COUNTY OF HARNETT LAND USE APPLICATION
Central Permitting 108 E. Front Street, Lillington, NC 27546 Phone: (910) 893-7525 Fax: (910) 893-2793 www.harnett.org

PROPERTY LOCATION: Subdivision: WOOD SHIRE Lot #: 166 Lot Size: 0.522

SURVEY FOR:
PROPOSED PLOT PLAN - LOT - 166
WOODSHIRE S/D, PHASE FIVE

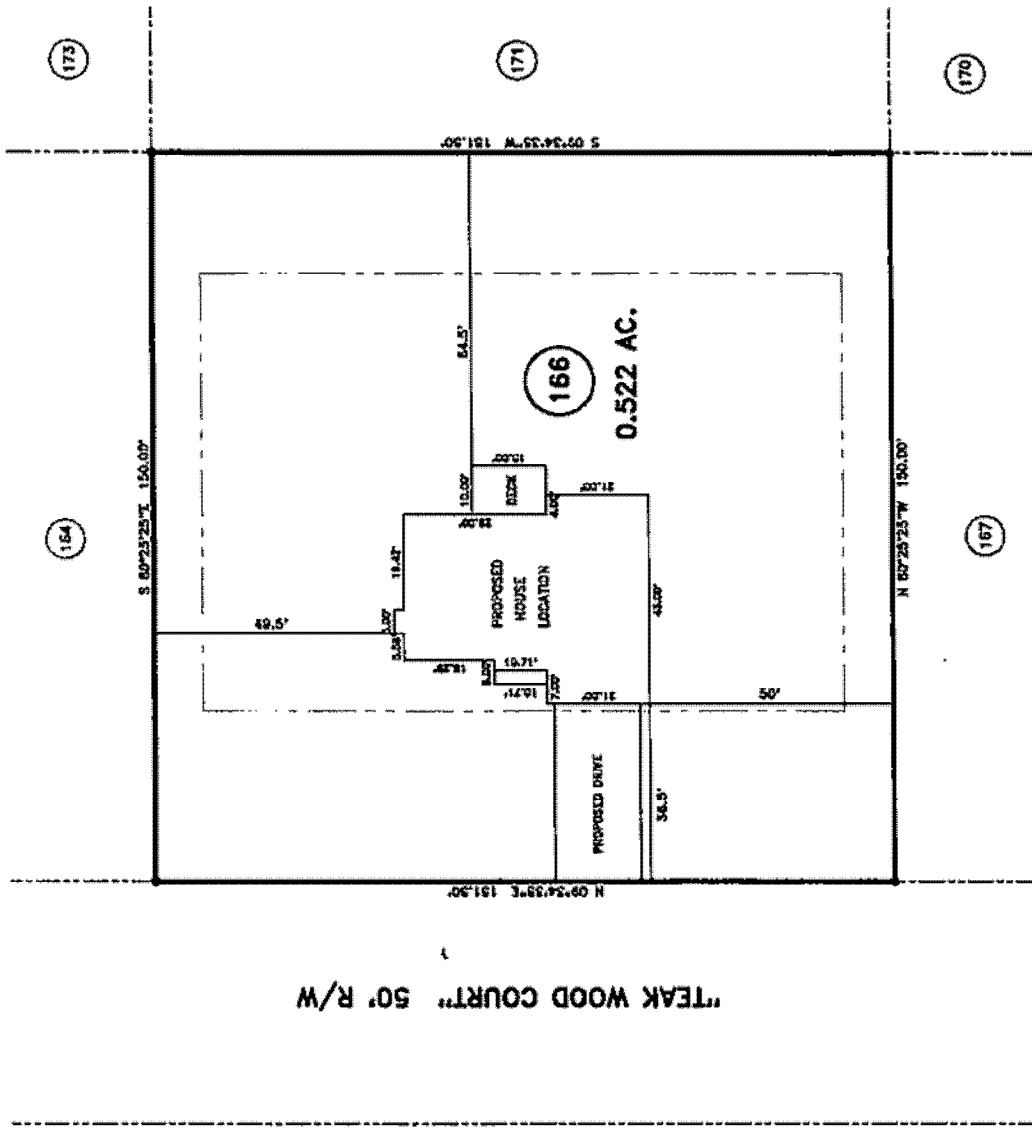
Required Residential Property Line Setbacks: Comments: 5/8 move house per EH
